MAJOR CASES

ACTION SHEET MINUTES: December 16, 2020

**SKETCH PLAT OF
TRACT A-1
FAIRVIEW PARK CEMETARY
SITUATE WITHIN
SECTION 27, T. 10 N., R. 3 E., N.M.P.M.
CITY OF ALBUQUERQUE
BERNALILLO COUNTY, NEW MEXICO
DECEMBER 2019**

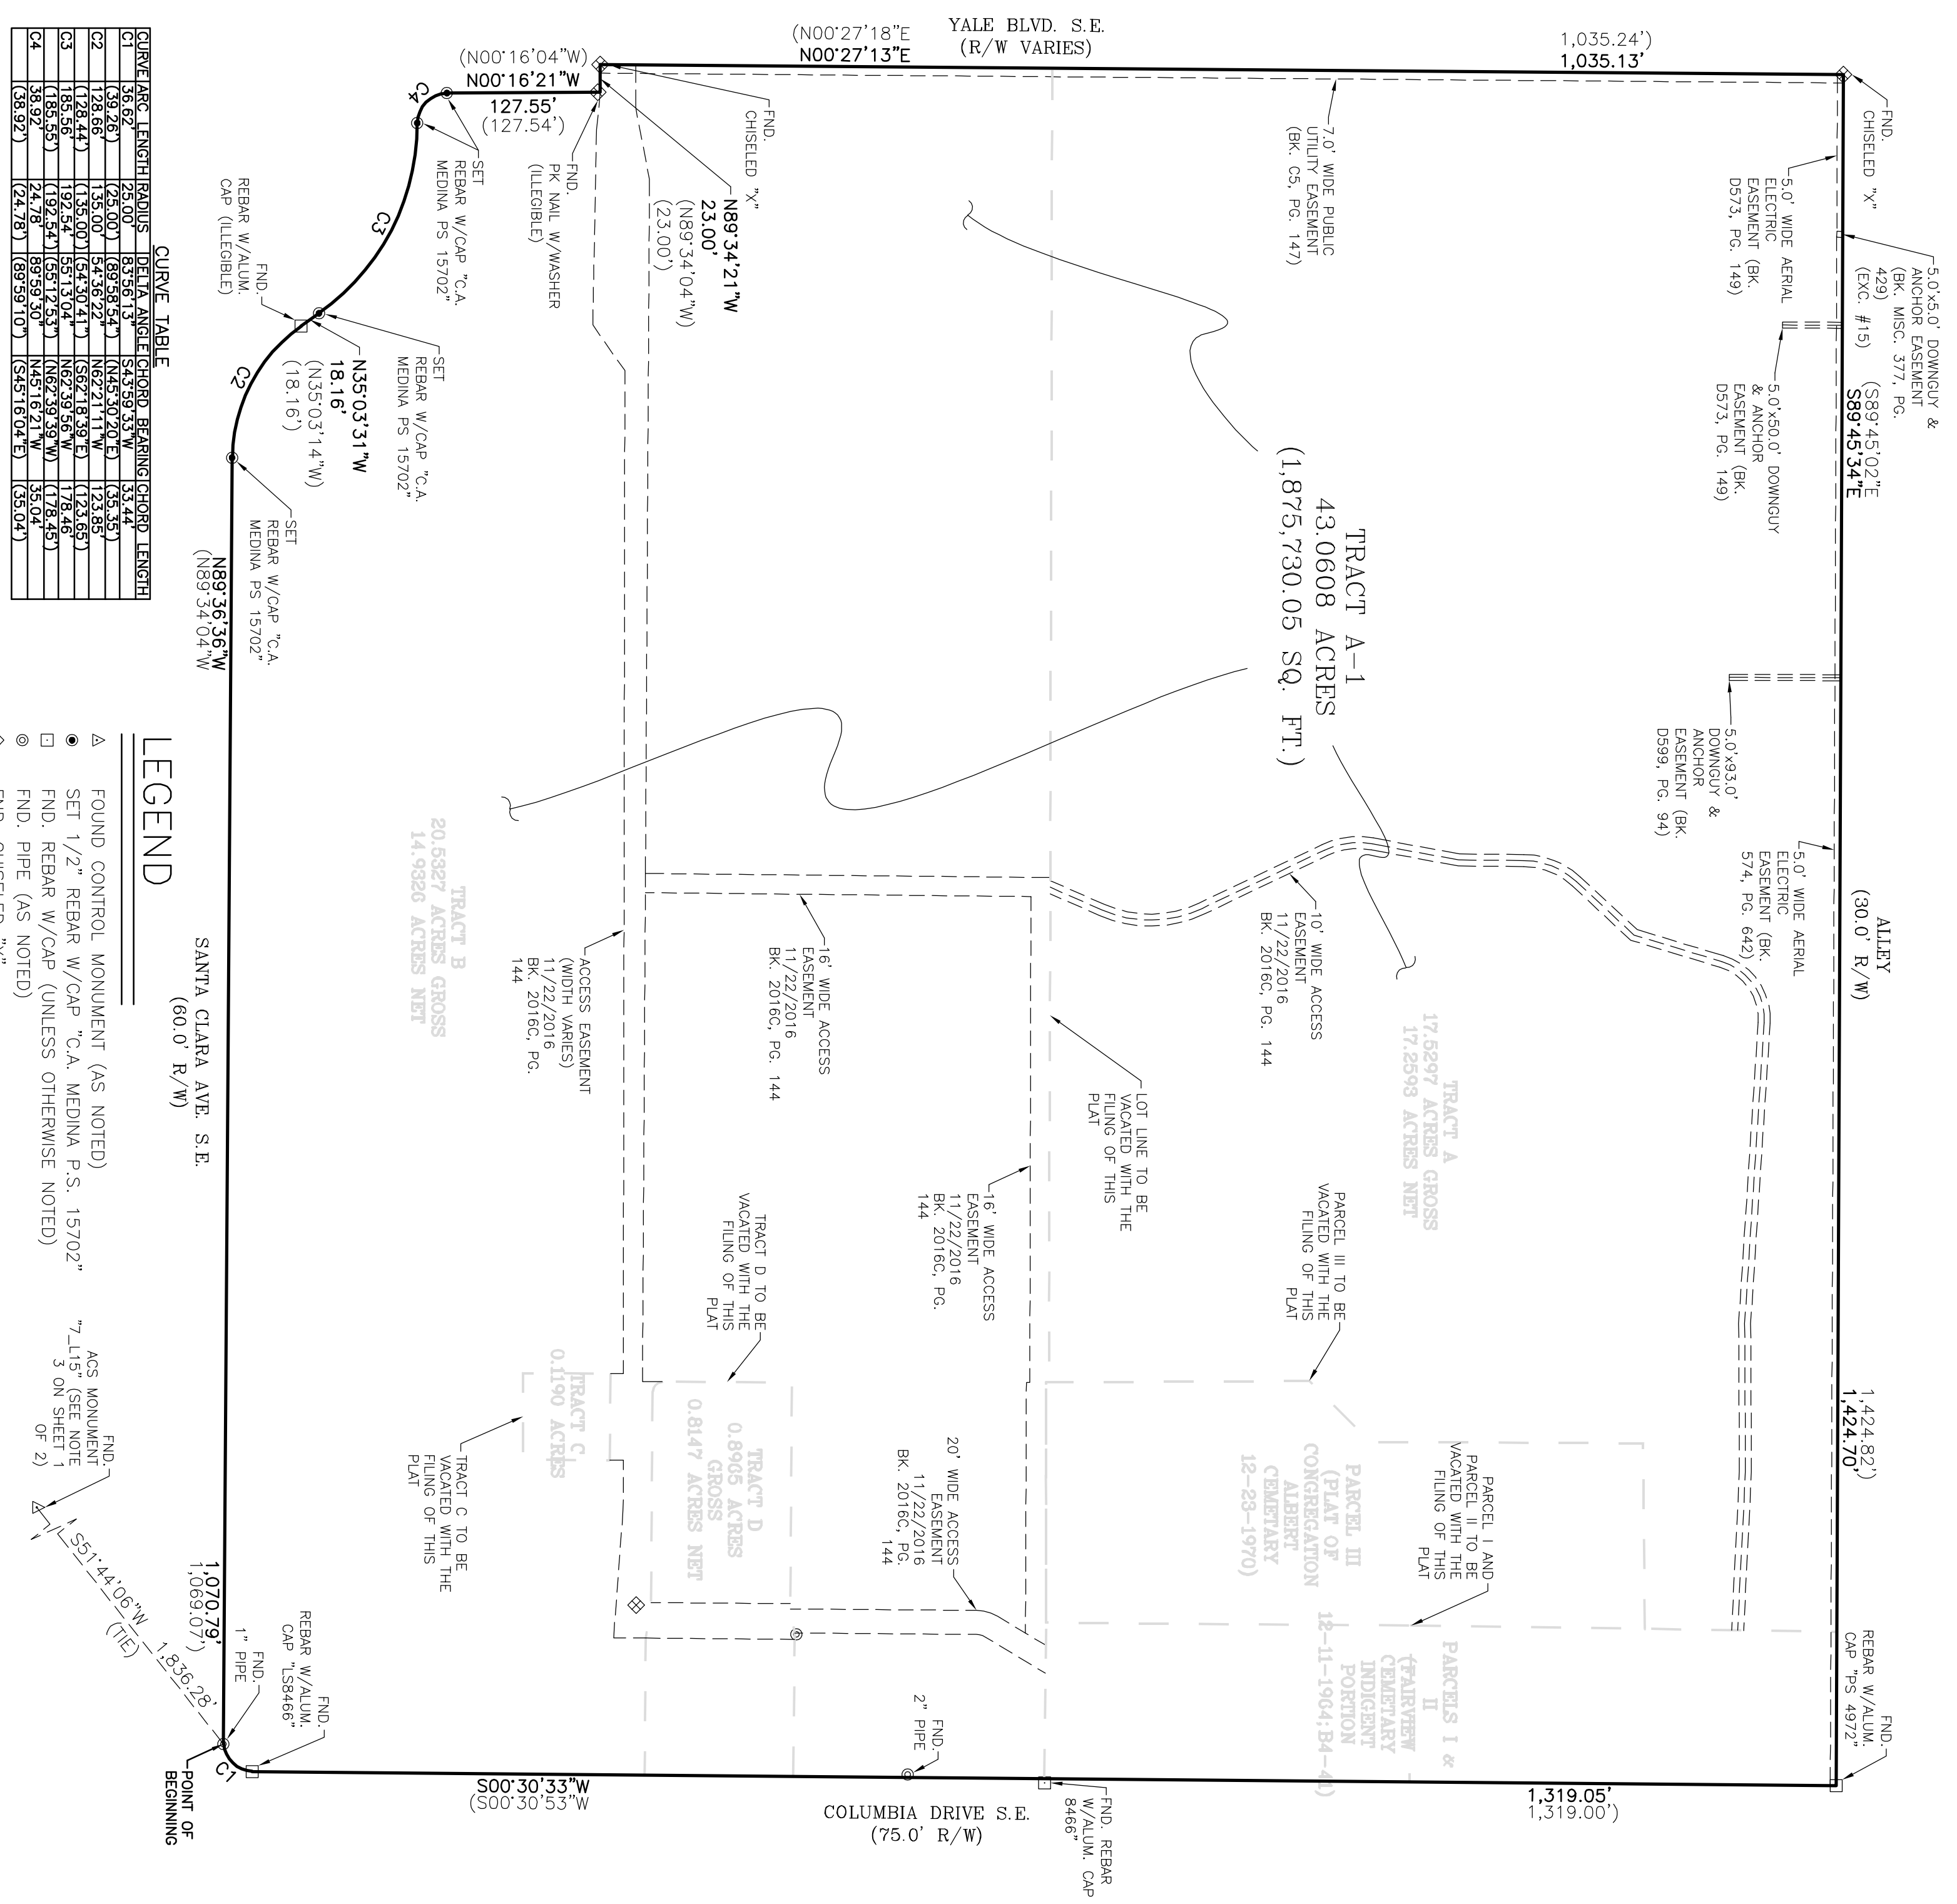
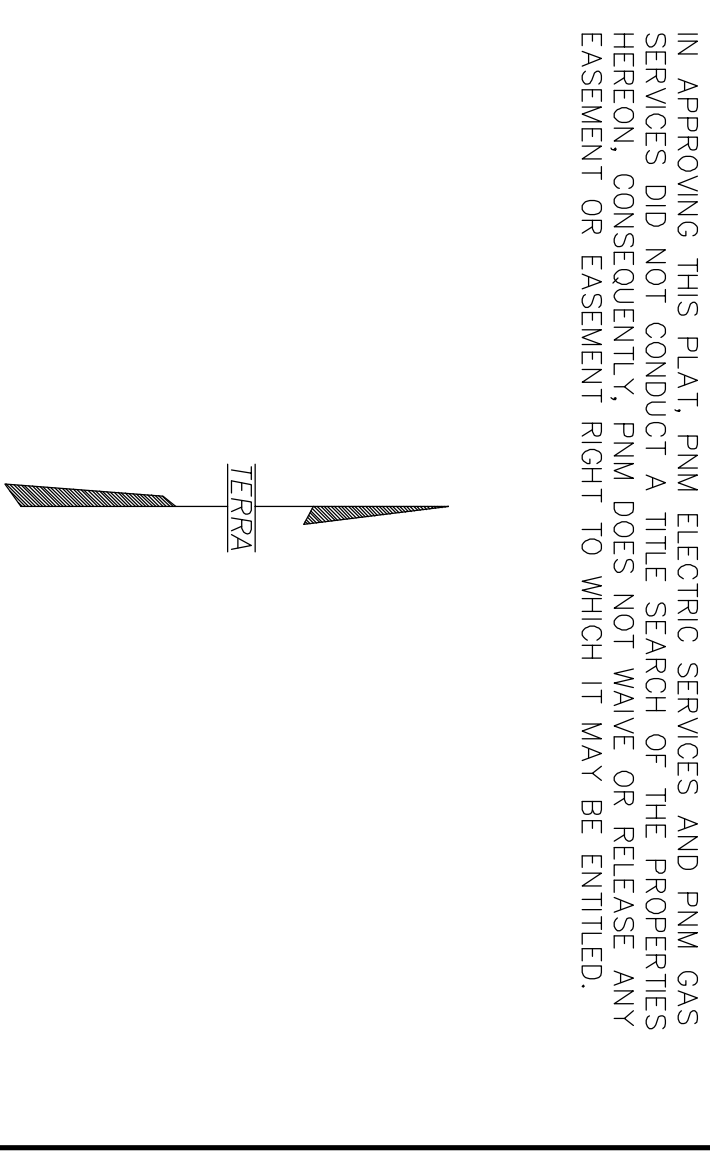
No Comments. No objection to the request.
